FROM: Chris Dye

SUBJECT: EP/58/11 - Replace 3 x existing estate entrance gates (this application falls within the parish of Rustington).

North End Of The Ridings & Angmering Lane, East End Of Tamarisk Way, East Preston, West Sussex

Hobdens Property Management Ltd	
Project:-	The Willowhayne
Road Name:-	The Ridings
Drawn By:-	Michael Cornwell
Scale:-	1:50
Date:-	31/05/2011
Drawing No. 2

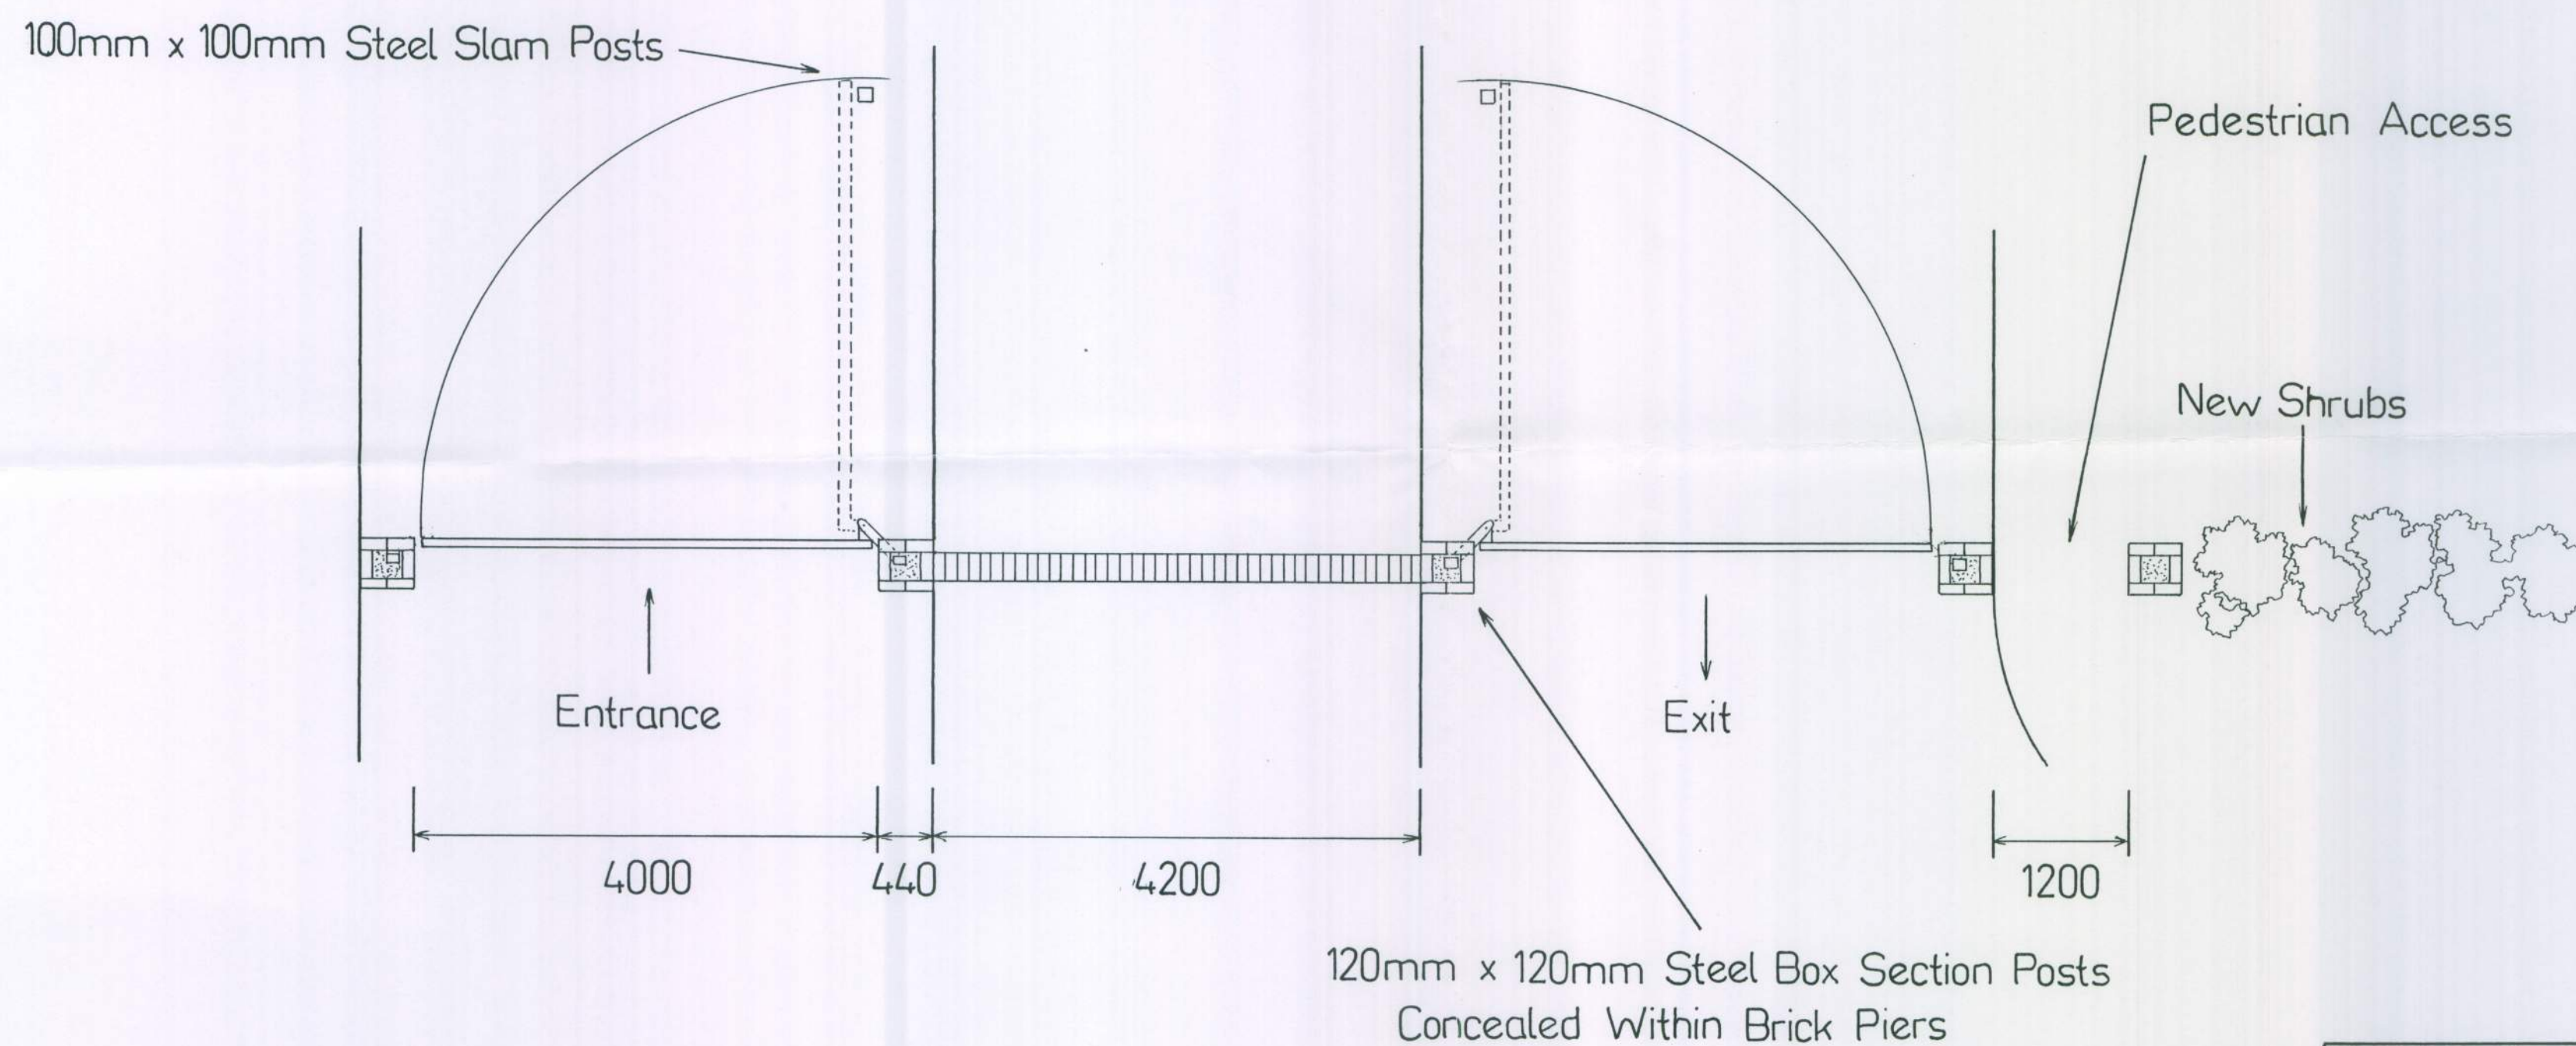
The applicant would be required to provide signage remote from the highway, indicating "in" and "out" to avoid any confusion, specifically at the Angmering Way and The Ridings sites.

If the LPA are minded to approve this application a condition securing "in" and "out" signs should be included.
